*Application for an Order granting Development Consent
for Botley West Solar Farm –(EN-010147)*

Botley West Solar Farm EN010147
Response by Stop Botley West (SBW)

Response to submissions of 16 July

Figure 3 - Central Area Masterplan Changes Animation

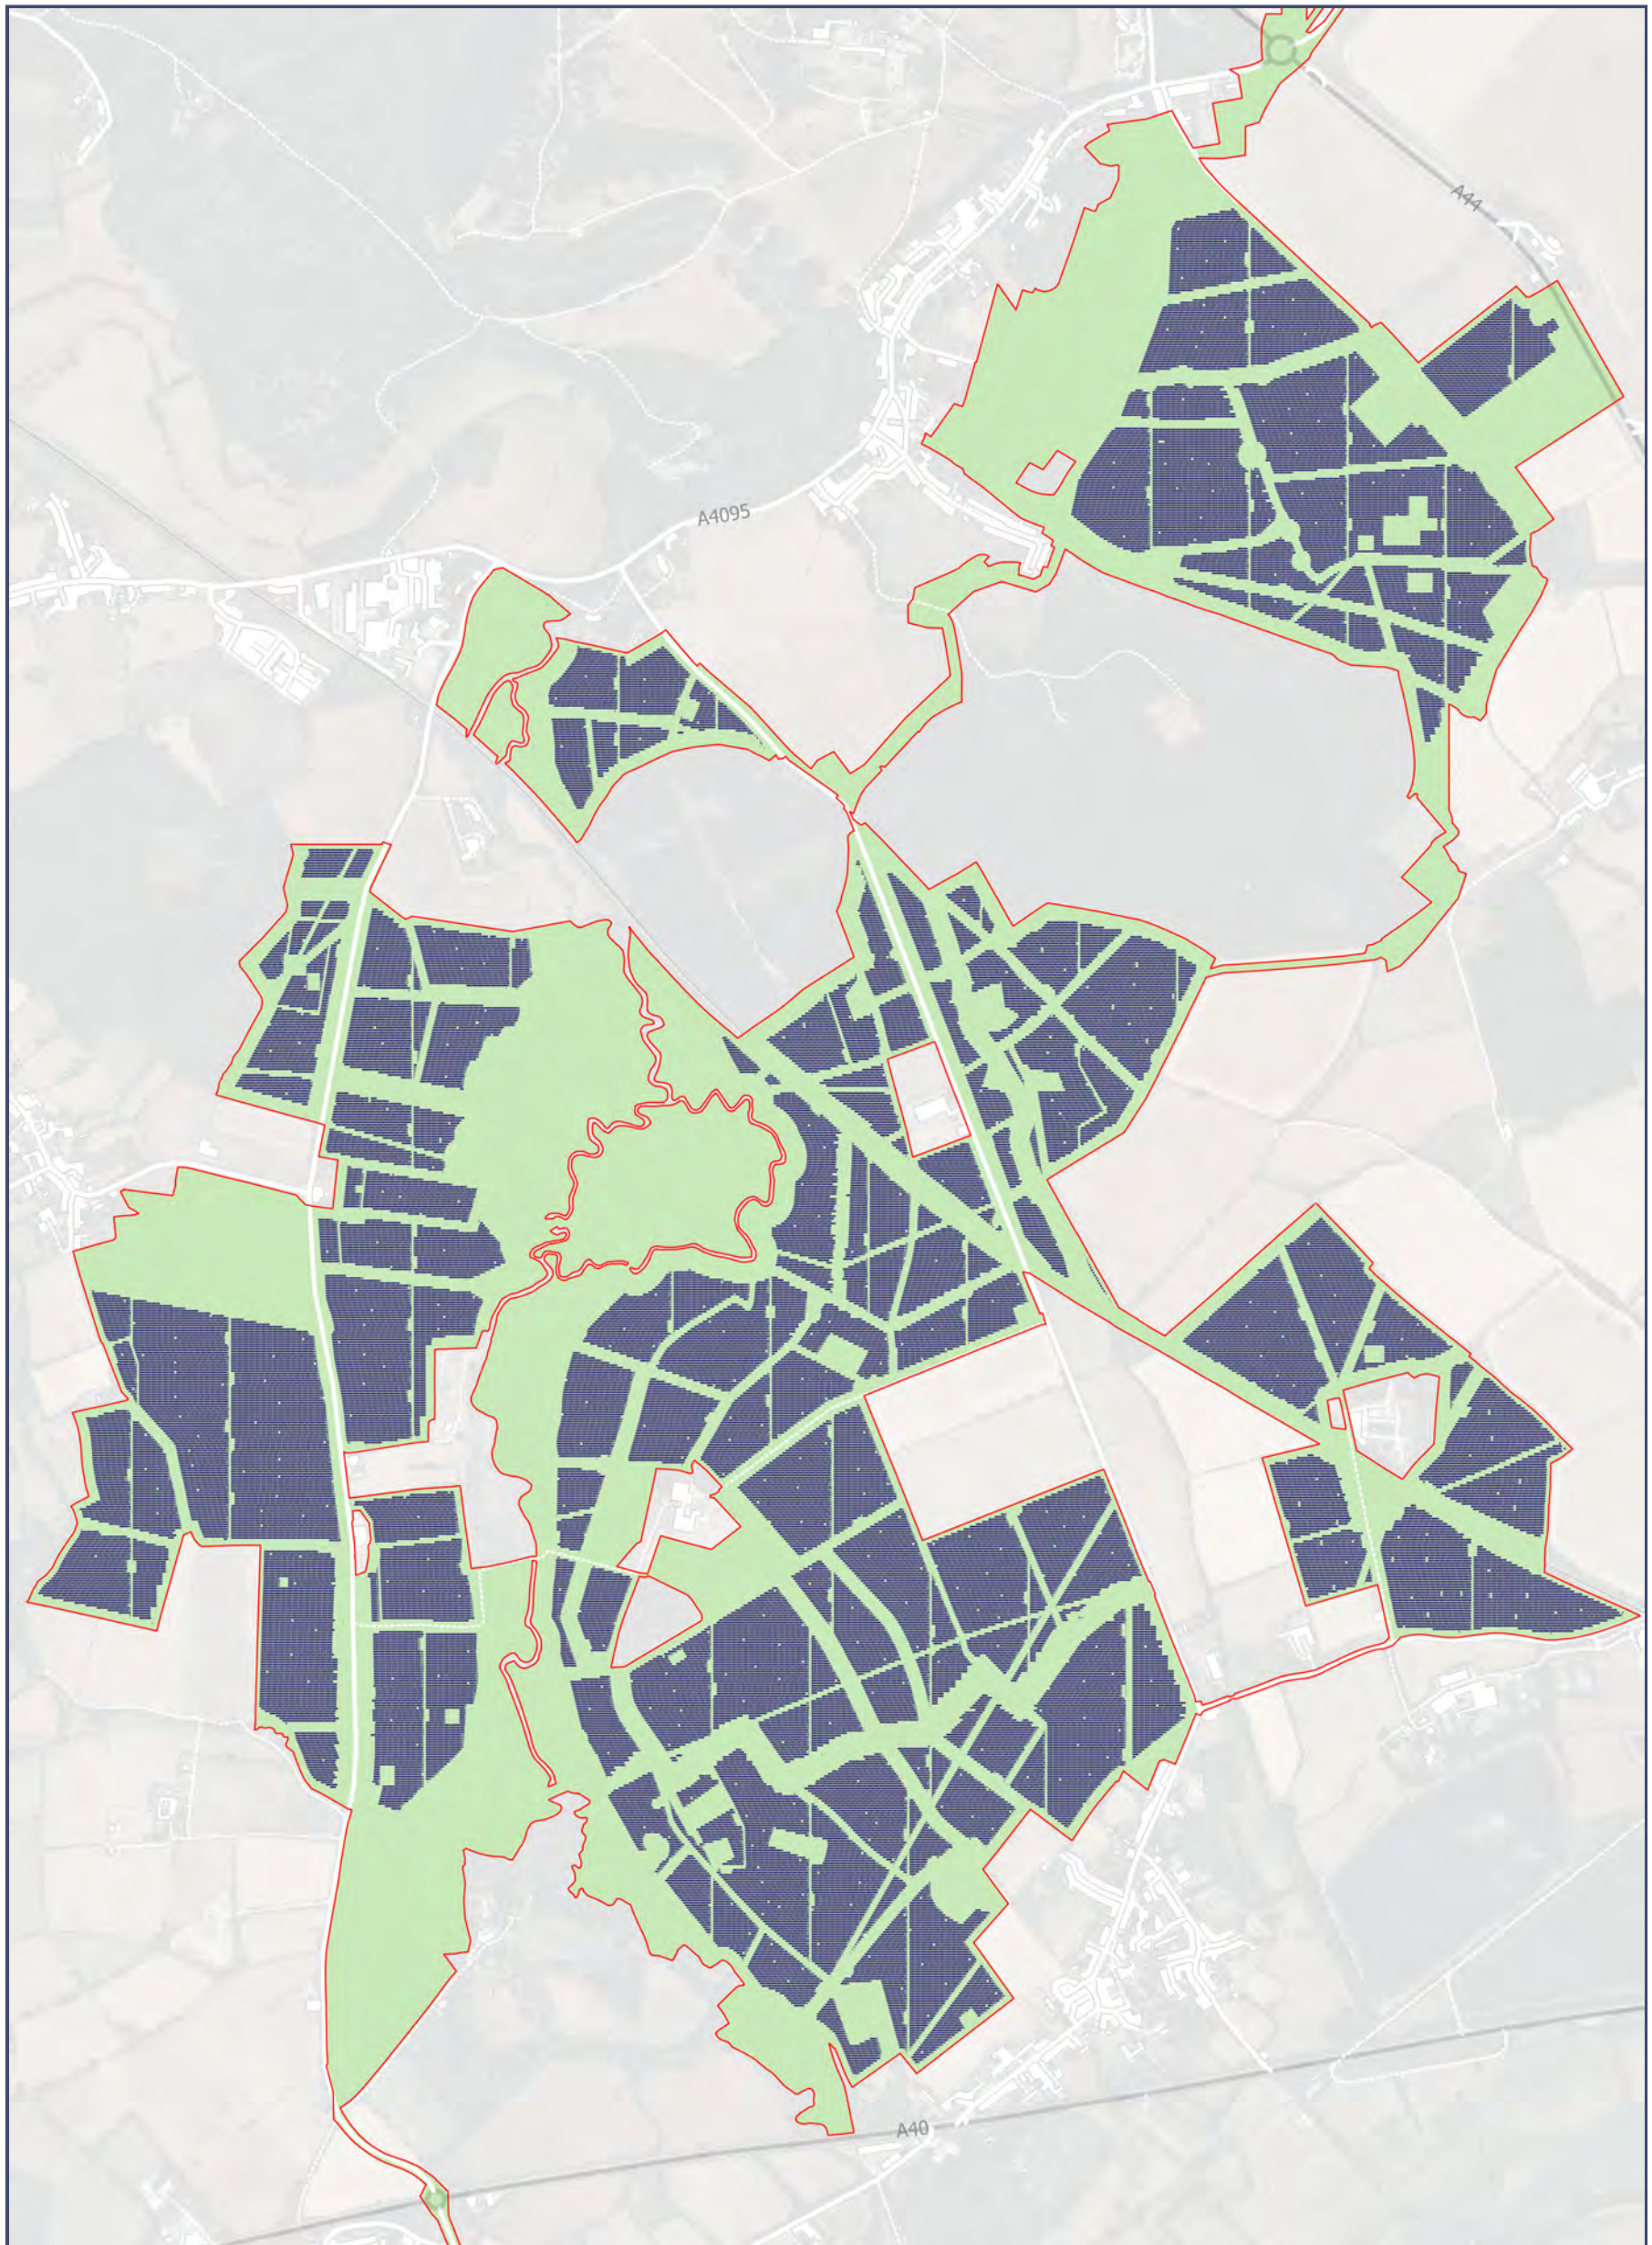
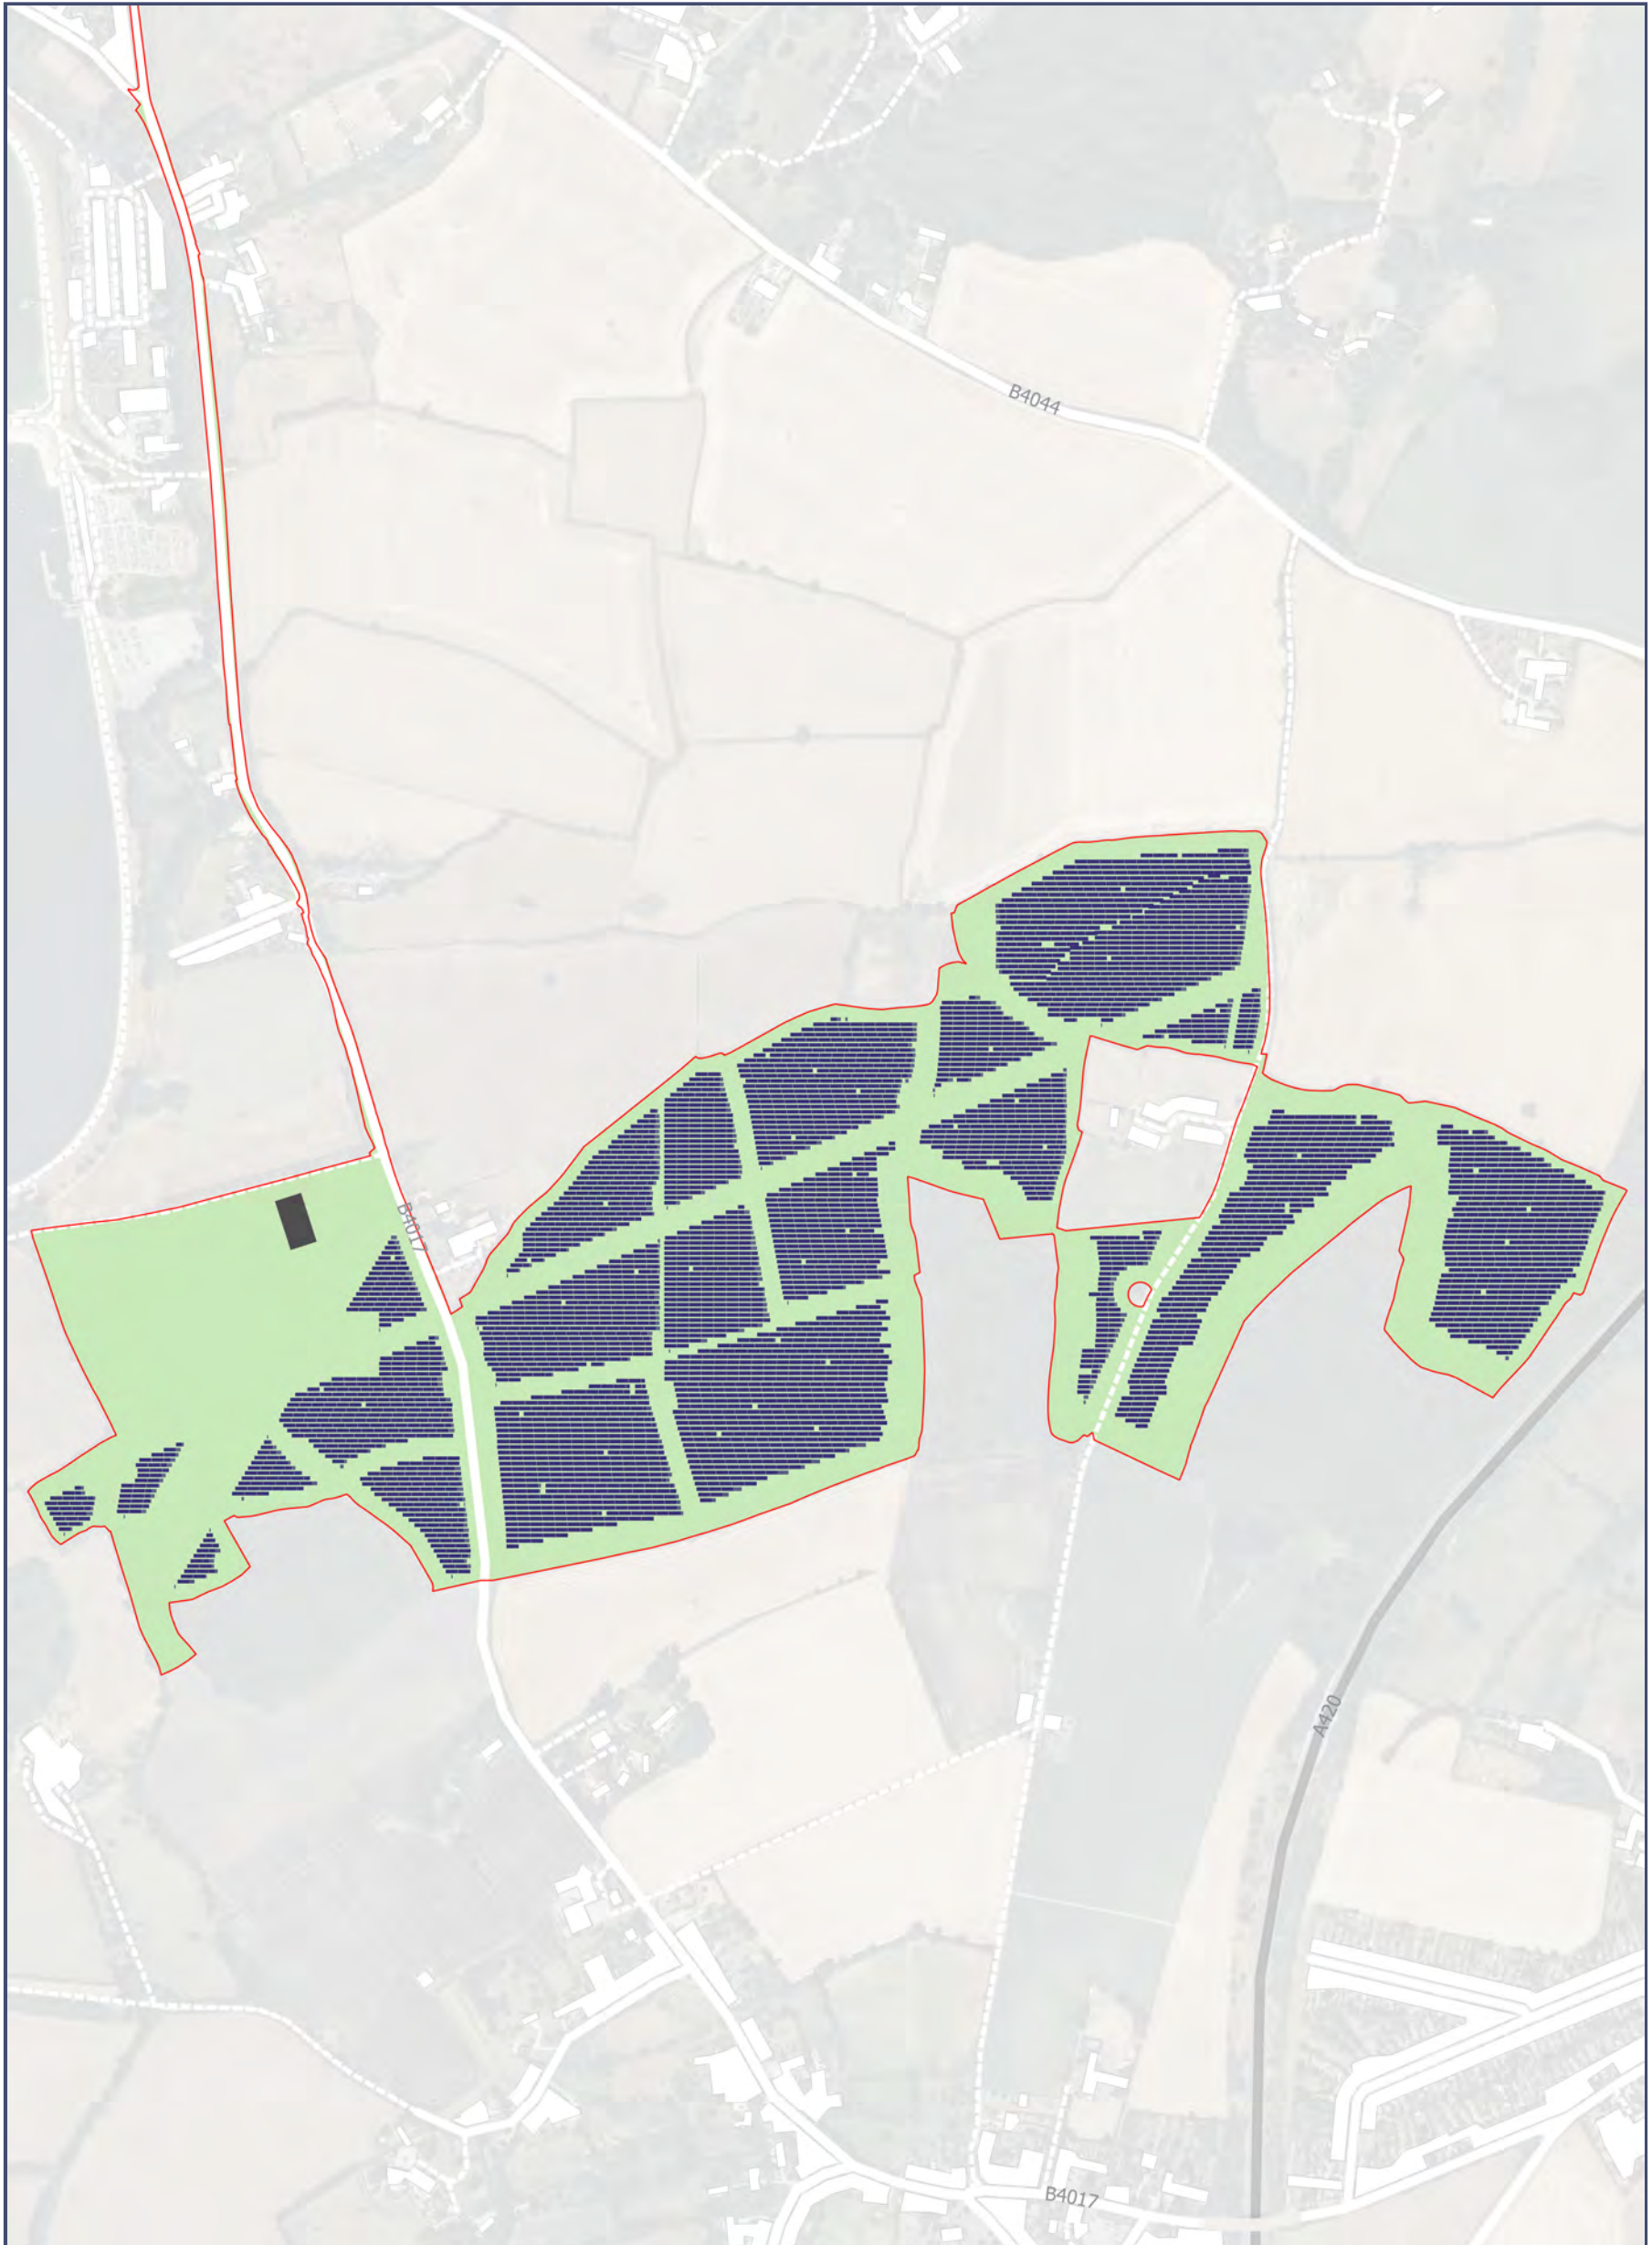
In the Applicant's latest (16 July) submission [C1-108, C1-109], its newly appointed consultants, Icen, have devised an "outline Residential Visual Amenity Plan" (oRVAP) Ref [C1-108] offering 100m as standard "with additional offsets up to 250m applied where needed". No criteria have been provided to explain how this "need" would be assessed post consent when it will be beyond public scrutiny.

Through this mechanism the Applicant has effectively changed the likely buffer for most properties to the minimum 100m instead of the buffer of 250m recommended by ExA and shown in the 9 June submission. By describing this change as an "improvement" comparing the new Masterplan (rev 5) with Masterplan rev3 of 11 Nov 2023 rather than with Masterplan rev4 of 9 June 2026, the Applicant has disguised the fact that the latest proposal is actually a regression.

June 9	July 16
Masterplan revision 4 [C1-051]	Masterplan revision 5 [C1-118]
Buffer of 250m shown	Buffer of 100m shown
New requirement 15 in Schedule 2 of dDCO describes a post consent RVAP (newly proposed on 9 June and not formally examined by ExA) which must set out justification for the distance proposed between 100m and 250m and must be approved by the local planning authority.	Amended requirement 15 in Schedule 2 of dDCO says: <i>"The RVAP must be substantially in accordance with the outline RVAP"</i> . Note: this oRVAP [newly proposed on 16 July] has not been formally examined by ExA nor approved by the local planning authority.
In response to the SoS request for information (letter 20/4/2026), the Applicant offered to increase the buffer distances from sensitive receptors [to 250m], as illustrated in the updated Masterplan Rev 4, stating: <i>"It is judged that these updates would result in beneficial effects for a number of individual residential receptors and settlement areas including, but not limited to, the residential visual amenity of Dornford Cottage, properties at Shipton Slade Farm, properties in Bladon, Burleigh House, College Farm and Church Hanborough"</i> .	Masterplan Rev 5. [C1-020] is informed by the new RVAA which repeats the previous errors in assessing whether vegetation already screens the property and consequently underestimates the impact on residential visual amenity for properties such as Dornford Cottage, Shipton Slade, College Farm, Goose Eye Farm and others. The effect of reducing the buffer to 100m would be to reverse the "beneficial effects" described on 9 June.

There is no justification for the most recent reduction of buffer size from 250m to 100m for most properties. Indeed, in its answer [C1-087] to question 27 of SoS 14 April letter, the Applicant admitted that that the project would still be viable, albeit marginally, with 250m buffers for all.

Masterplan revision 5 [C1-118] submitted on 16 July conversely shows buffers of **100m**.
